**WEST SUSSEX COUNTY COUNCIL
STRATEGIC PLANNING CONSULTATION**

SUBJECT: P/76/16/PL - Construction of a building for the packaging, preparation & distribution of fresh foods with ancillary accommodation associated with the existing horticultural business, revisions to internal access road, car parking & hardstanding areas & landscaping & provision of a wetland. This application affects the setting of Listed Buildings.

LOCATION: Sefter Farm, Pagham Road, Bognor Regis, West Sussex, PO21 3PX.

This is the fifth WSCC highways and transport response to the planning application. It follows a meeting with the applicant and assessment of additional information provided by the applicant's highway consultant (revised Designer's Response to Stage 1 Road Safety Audit and associated drawings (020.0259.004 and 020.0259.005)) prepared by Paul Basham Associates (PBA) to Tim Townsend WSCC Highway Authority (CHA).

**Figure 3:** Existing Car Parking Provision ([www.googlemaps.com](http://www.googlemaps.com))

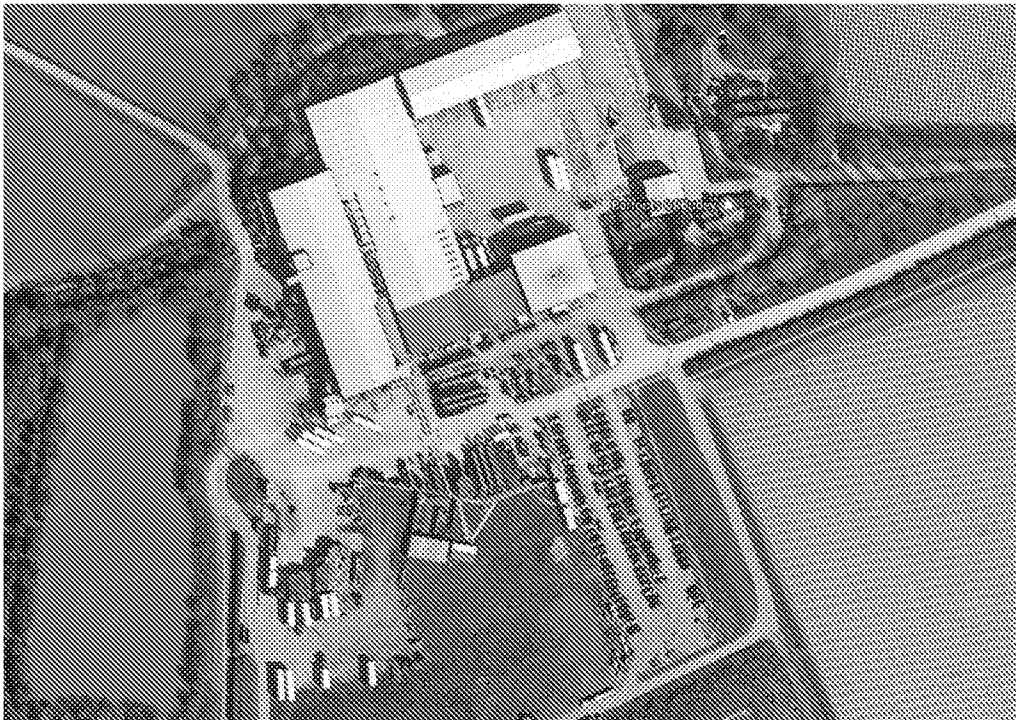
From both on-site observation and scrutiny of 'Google Streetview', the existing car park currently provides about 130 car parking spaces and appears to be already well-used. The applicant's planning consultant suggests that 170 spaces are available, albeit unmarked on a gravel surface. He goes on to say that if the spaces are marked-out, approximately 215 spaces could be provided. PBA's assessment of the situation suggests the following:

- Main car park – 175 spaces
- Main reception – 30 spaces
- Current main office – 5 spaces
- AD Plant – 5 spaces

Total: 215. This concurs with the previous consultant's assessment.

Following further discussion with the applicant and their agents, it is proposed to provide a car parking large enough to cater for 215 spaces but left unmarked for informality given the rural setting. However, if it appears that this parking is not being used to good effect, then the applicant is agreeable to marking-out the spaces to maximise numbers. An obligation should be included in the final Travel Plan to secure this.

SCALE: 1:1000

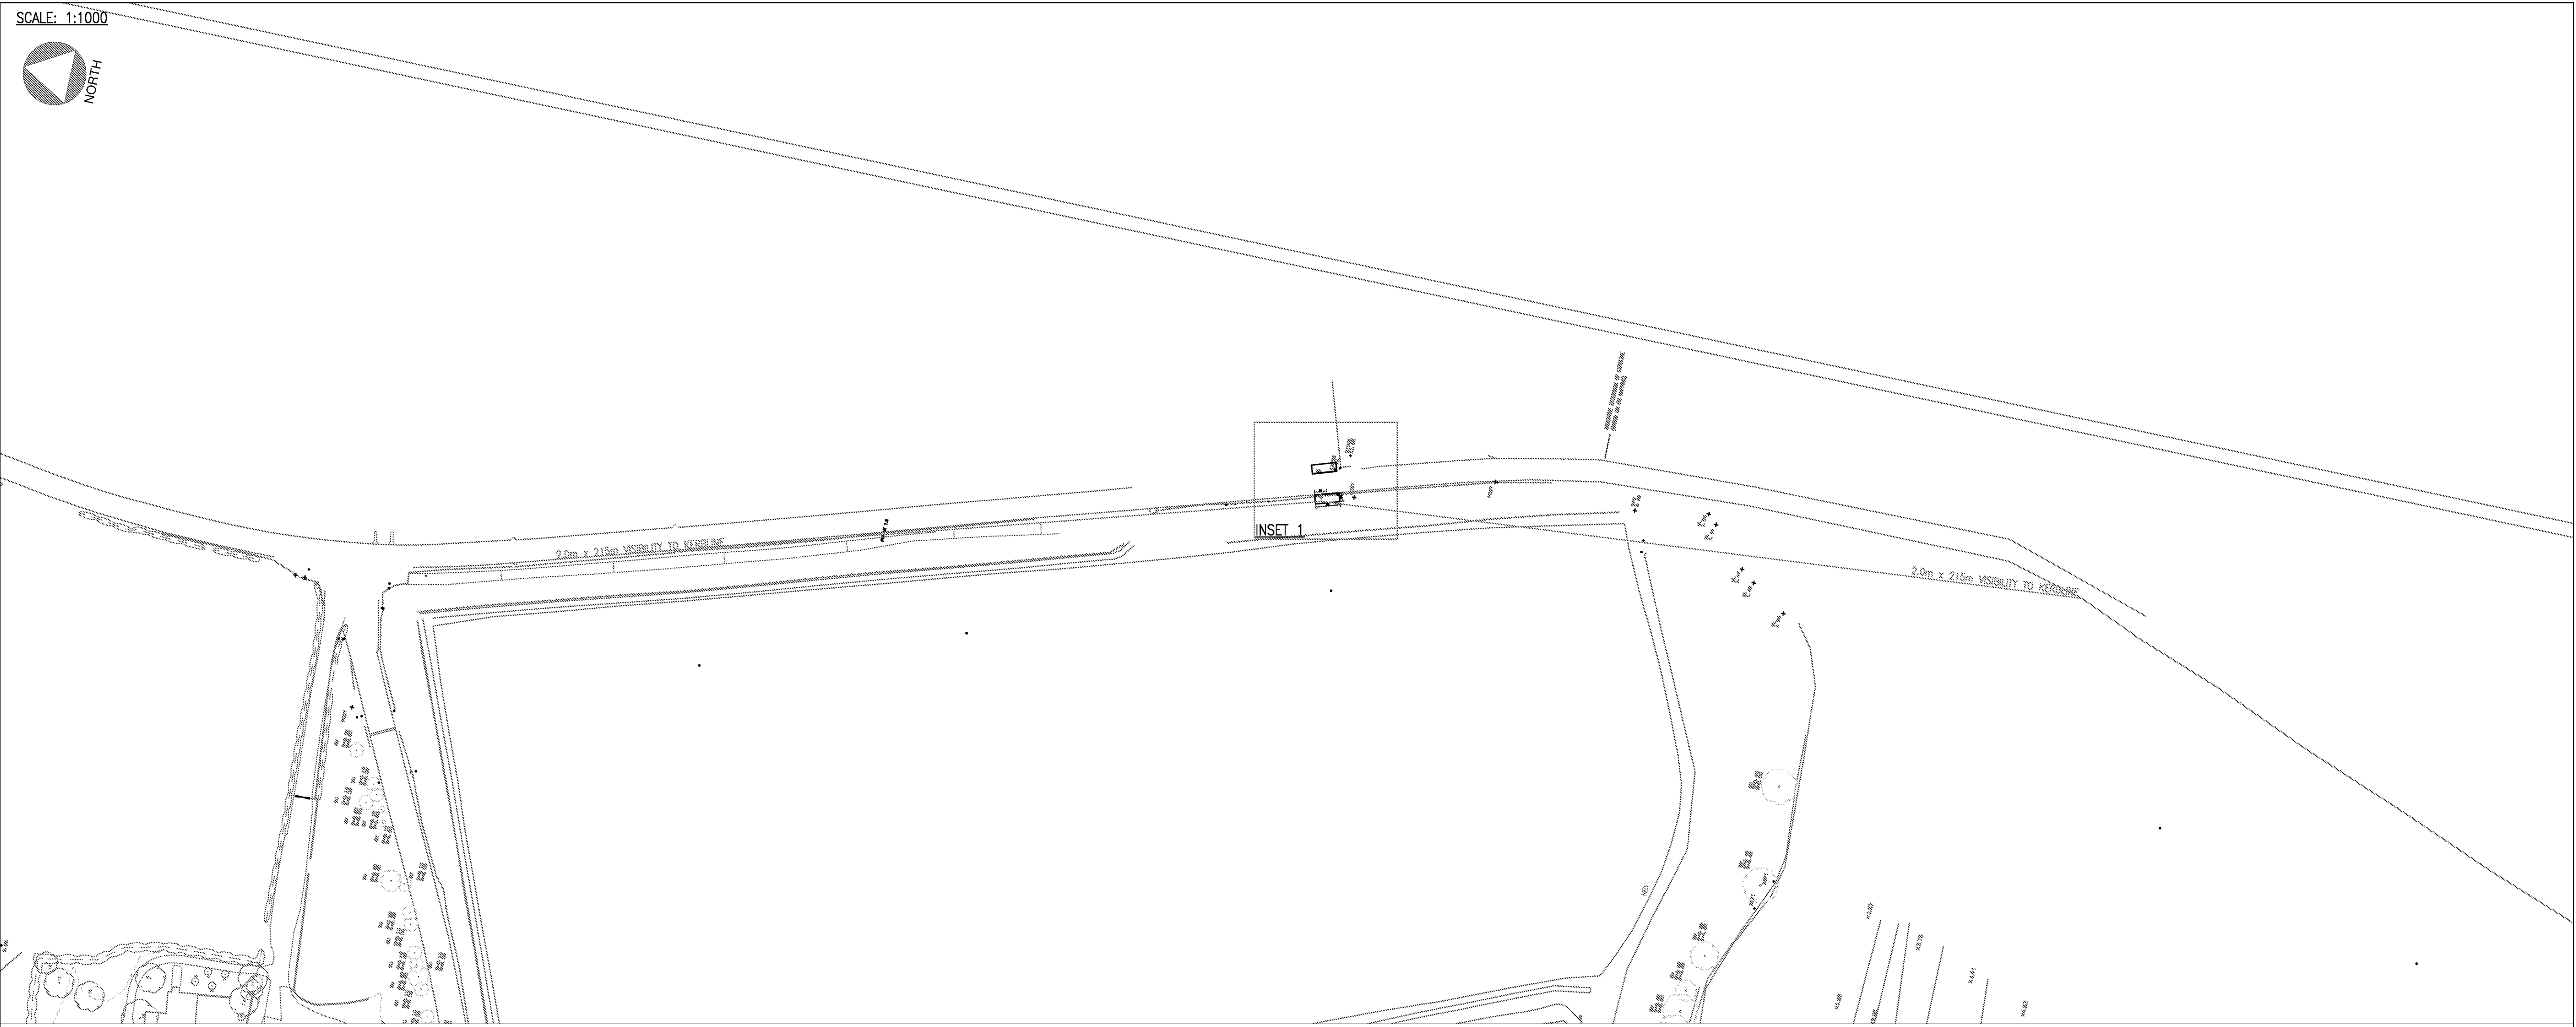
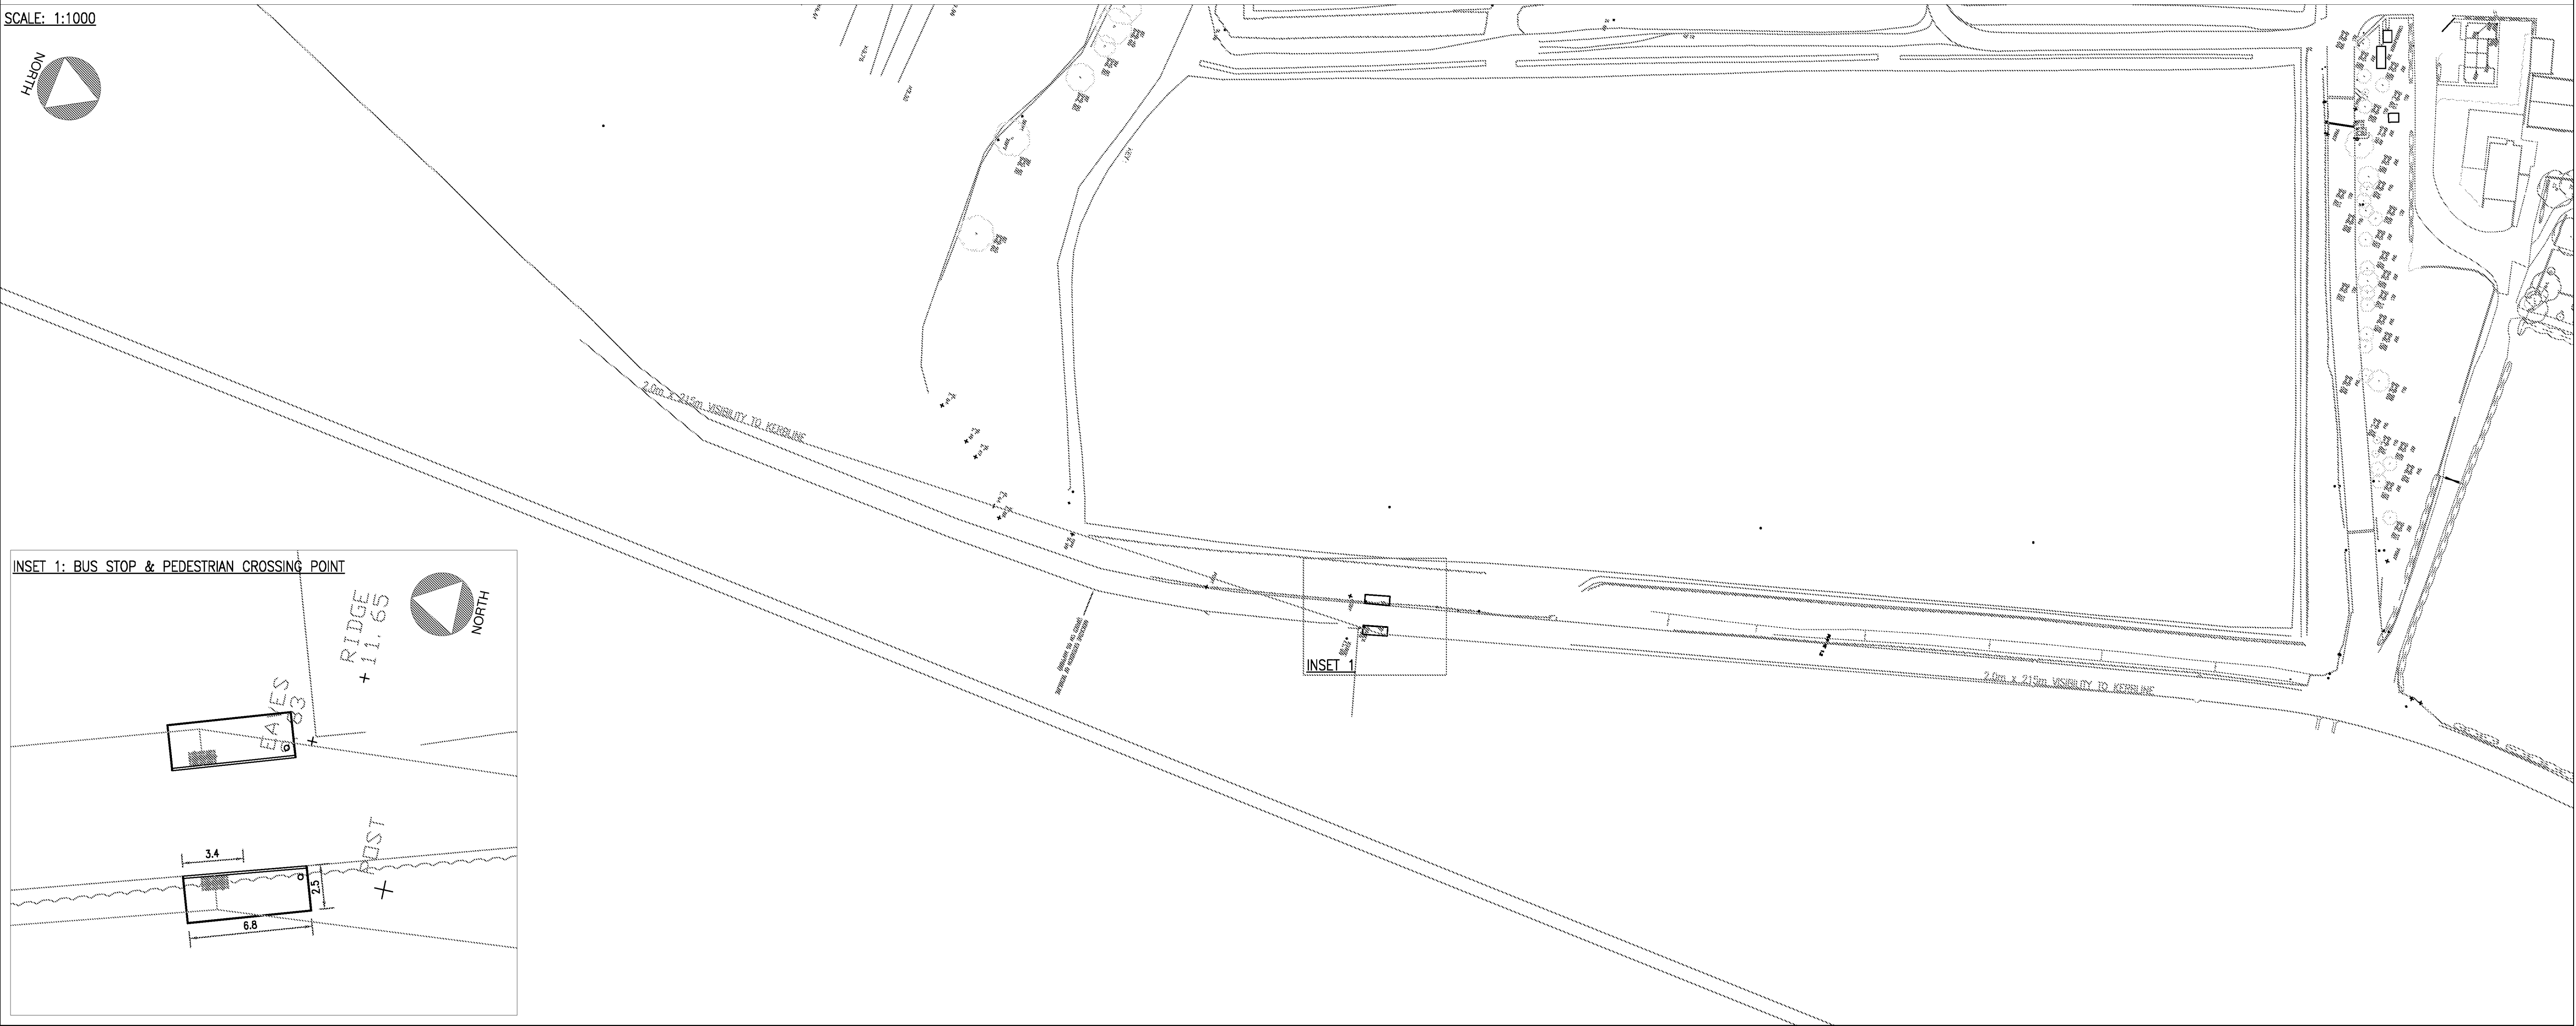
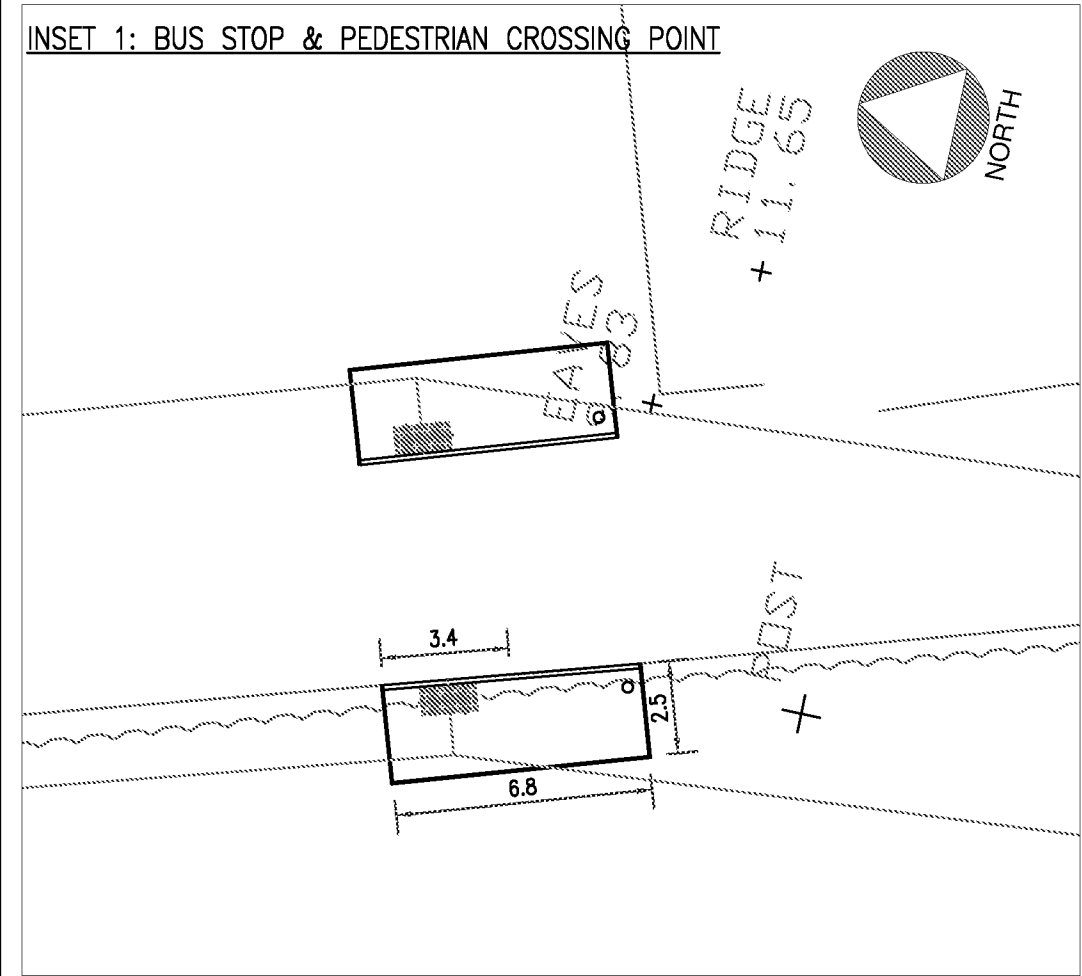
Accesses (vehicular and pedestrian) - Turning to suitability of the access and road safety considerations thereof, The CHA, Road Safety Report and Stage 1 Road Safety Audit all identified shortcomings with the vehicular and pedestrian accesses to the site. Following production of drawings 020.0259.004 and 020.0259.005 and further assessment of the Road Safety Audit recommendations, the Highway Authority is satisfied with the information now shown – i.e. that improvements can be made to both to improve visibility at both access points to the site. For all areas under the control of the applicants, they should maintain the visibility. For areas deemed to be highway, it is recommended that the applicant also maintains using a 'licence to maintain', obtainable from the Highway Authority which permits an appropriately qualified contractor to do the work on the applicant's behalf subject to appropriate traffic management and other health and safety requirements. The Area Highway Engineer should be approached to secure this licence.

Reason – To ensure fit-for-purpose accesses to and from the site constructed to a suitable standard and in-compliance with Road Safety recommendations.
